from
**Southern
Water**

Your ref
M/143/18/PL

Proposal: Erection of a new 4 bedroom dwelling.

Site: M/143/18/PL: - 66, Ancton Way, Elmer, Middleton-On-Sea, PO22 6JP.

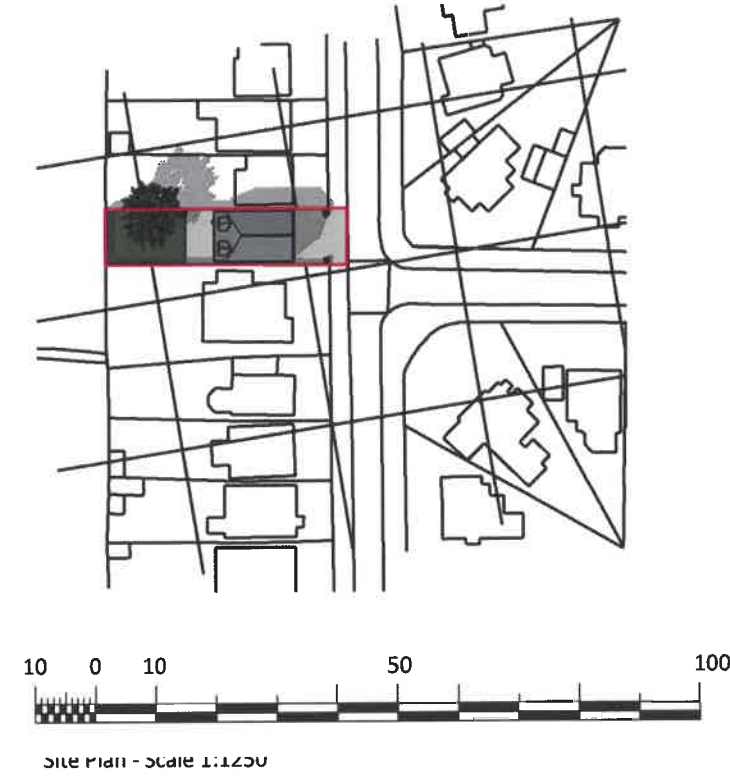
Please find attached a plan of the sewer records showing the approximate position of a public foul rising main in the access of the site. The exact position of the public foul rising main must be determined on site by the applicant before the layout of the proposed development is finalised.

- No development or tree planting should be carried out within 3 metres of the external edge of the public foul rising mains without consent from Southern Water.
- No soakaways, swales, ponds, watercourses or any other surface water retaining or conveying features should be located within 5 metres of a public rising mains.
- All existing infrastructure should be protected during the course of construction works.

Our initial investigations indicate that there are no public surface water sewers in the vicinity of the area to serve this development. Alternative means of draining surface water from this development are required. This should not involve disposal to a public foul sewer.
